Our Ref: P/42/26/NMA

Non material amendment following P/49/21/RES to change the canopies for plots 93 and 94 from flat style to apex style.

Land north of Sefter Road 80 Rose Green Road Pagham

GRP Trussed Apex Door Canopy

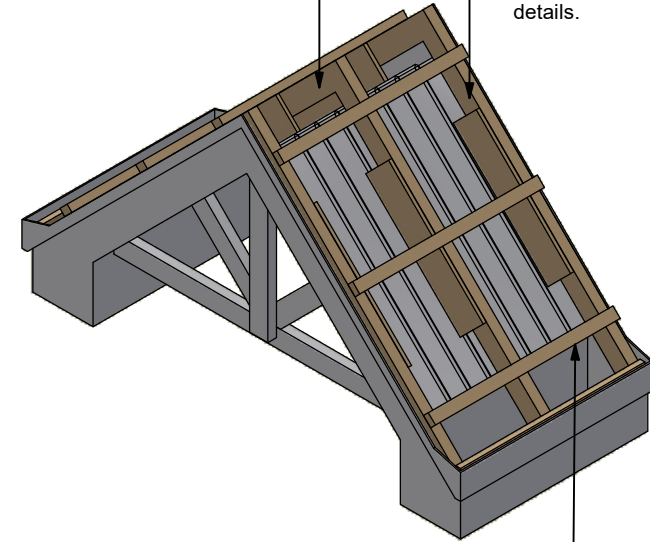
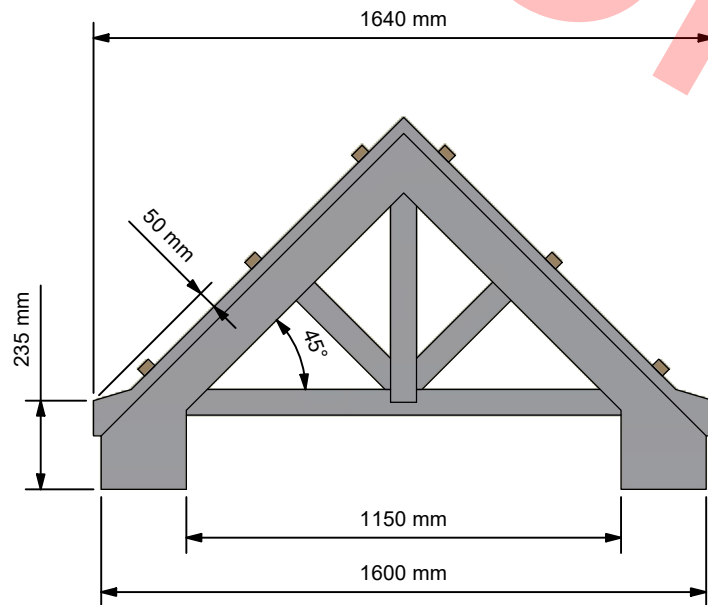
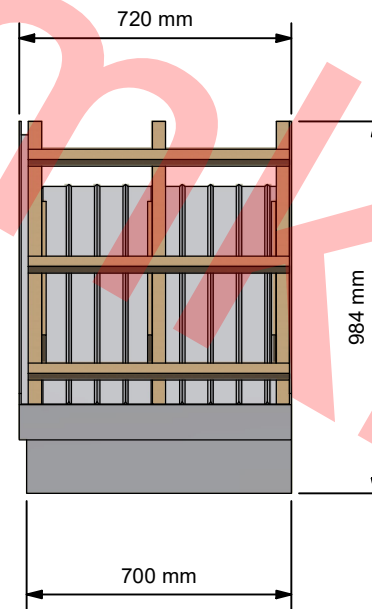
I refer to your recent application for a Non Material Minor Amendment. You propose to amend the porch design on plots 93 and 94 from a flat roof design to an apex roof.

You have not specified the colour or type of roof tiles to be affixed to the apex roof so for the avoidance of doubt this decision is made on the basis that the tiles will match those on the main roofs of these two plots.
